**WRITTEN REPRESENTATION
OF PD PORT SERVICES LIMITED**

Application by Chrysaor Production (U.K.) Limited ("Chrysaor") for an Order Granting
Development Consent for the Viking CCS Pipeline ("the Project")

ACCESS AND RIGHTS OF WAY PLAN
REGULATION 5(2)(k)
APPLICATION DOCUMENT REFERENCE 4.20
SHEET 5 OF 36

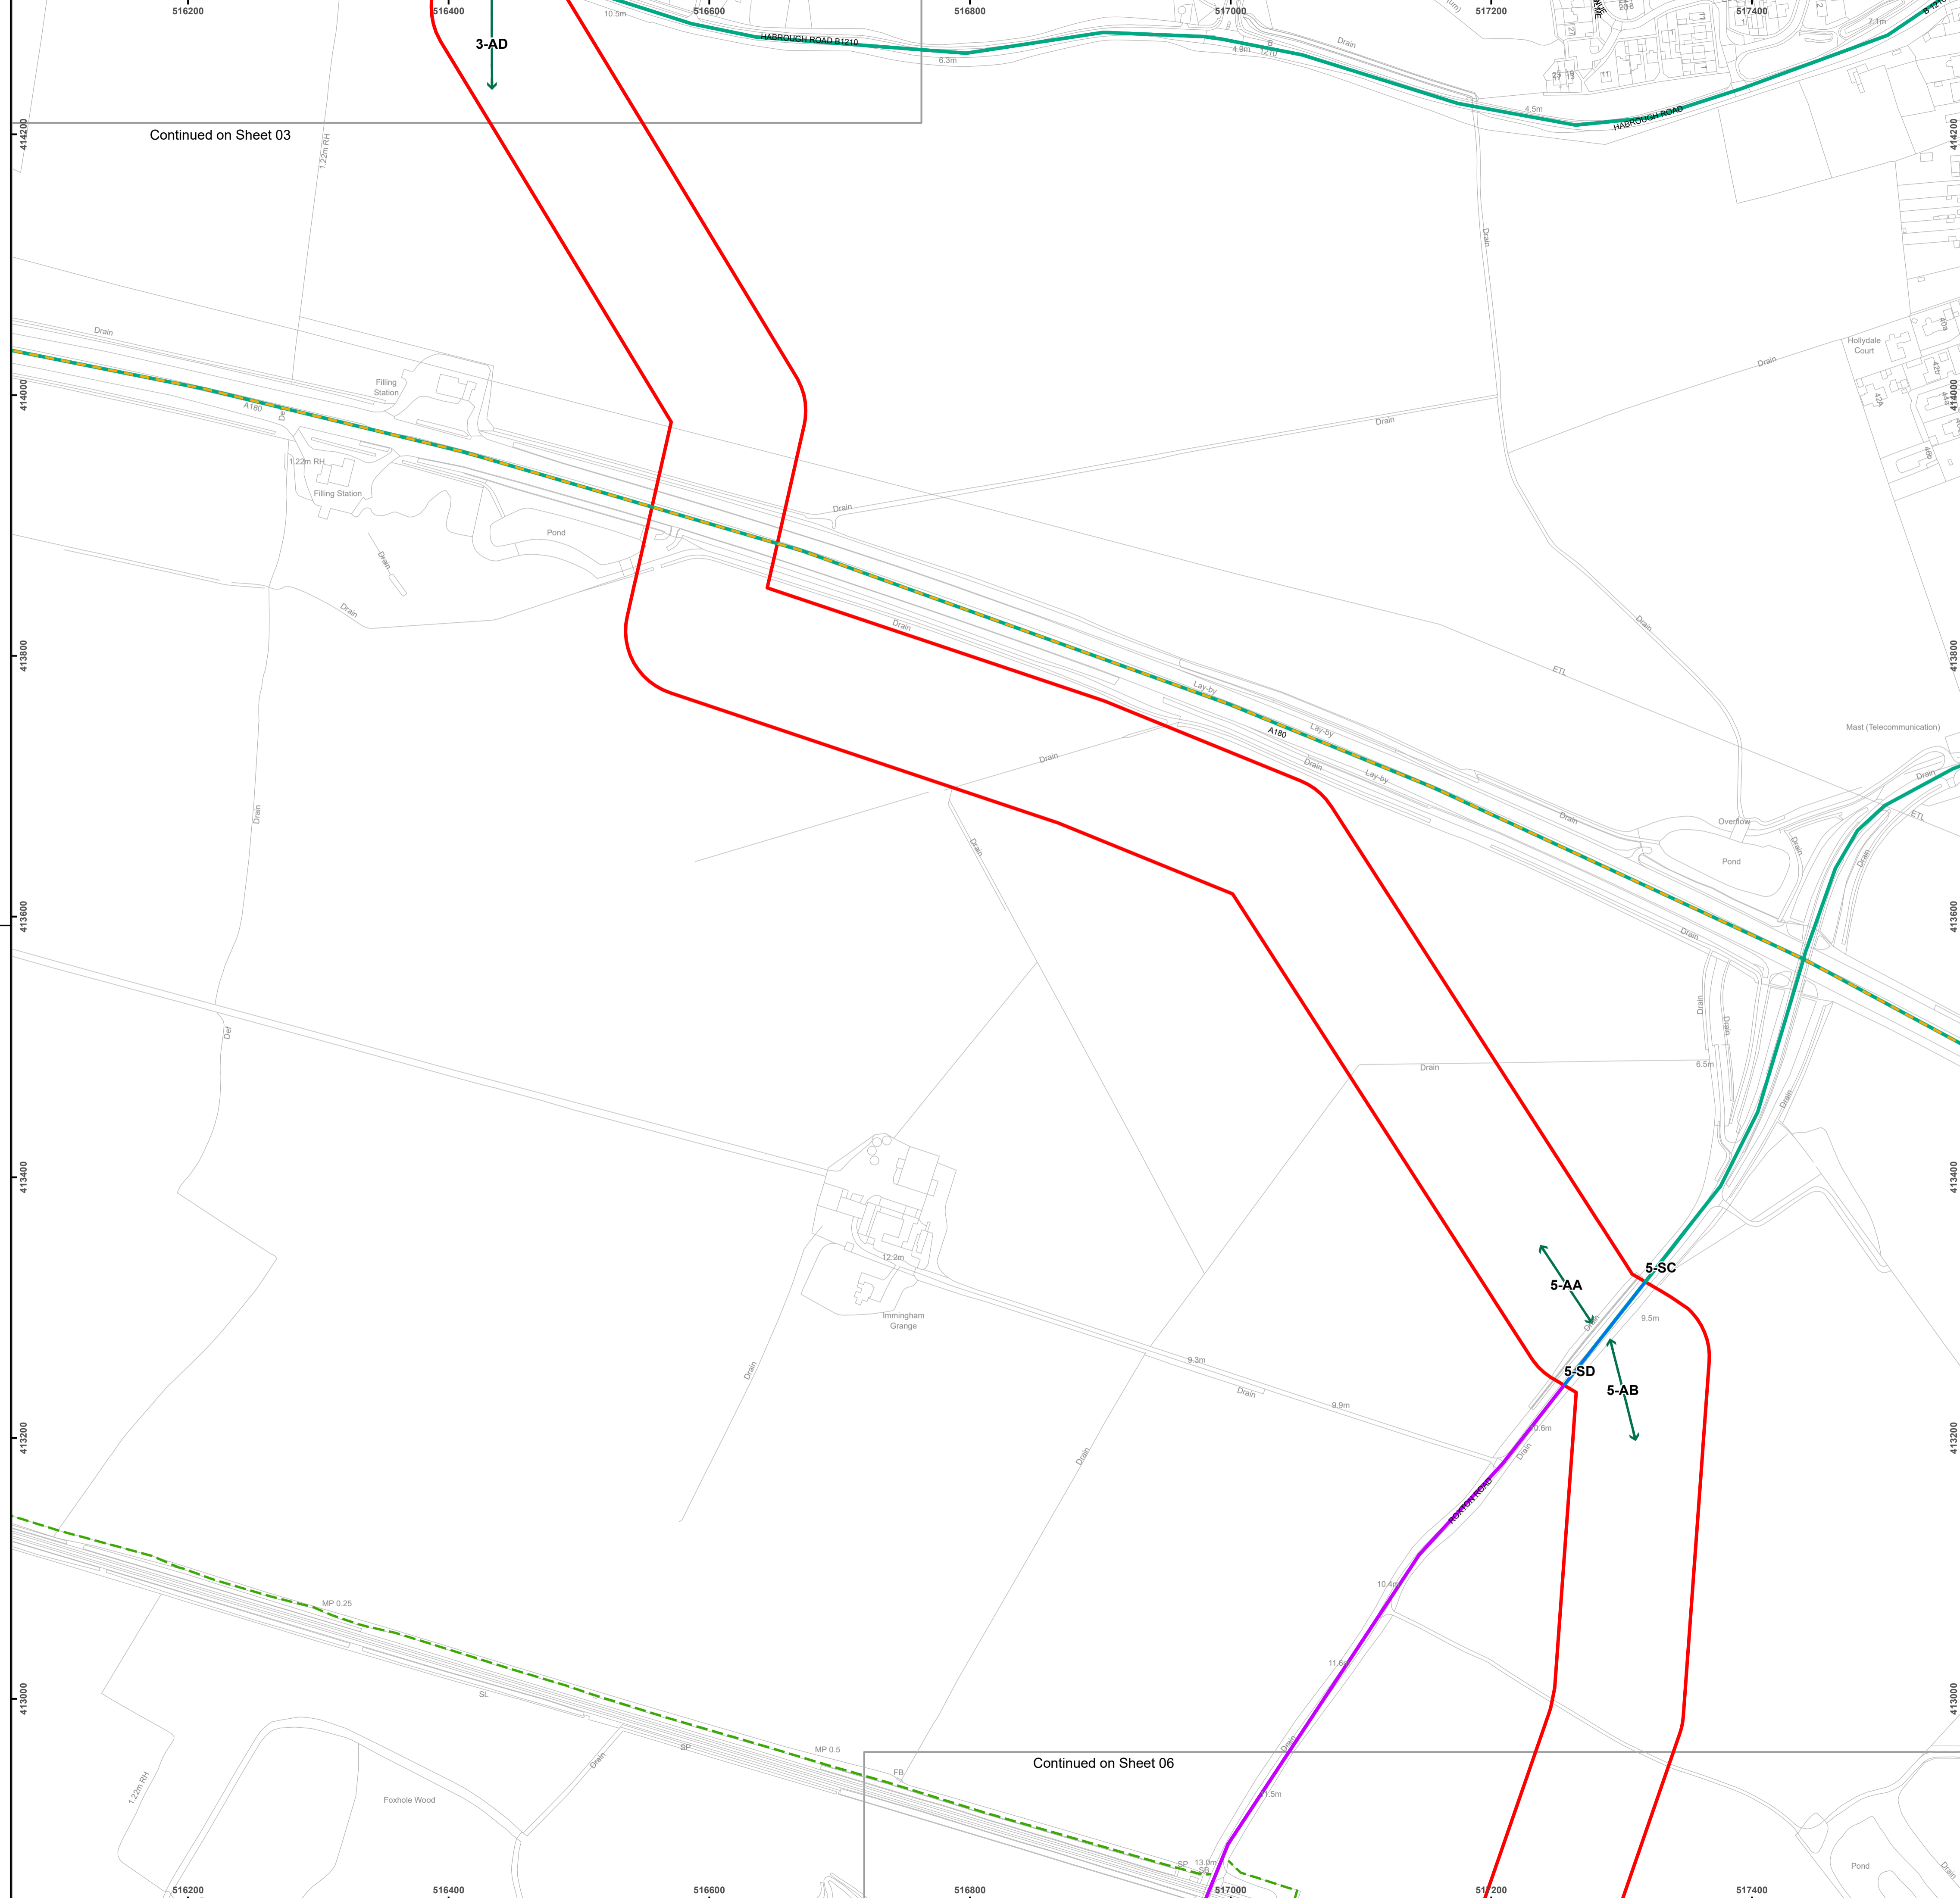
10. The Project proposes works along the A180 and A1173 as shown at Sheets 5 and 8 (at Point 8-SB) of the Public Access and Rights of Way Plan [APP-033]. These works may affect access to and from Laporte Road and potentially interfere with PD Ports' operations. It is unclear how access will be maintained while the IGET diversions are also in place and that these will not result in a further interference with PD Ports' operations.

11. Further, PD Ports considers there is a lack of information provided by Chrysaor with respect to vehicle restrictions, particularly regarding potential weight and height restrictions on the A180 and A1173.
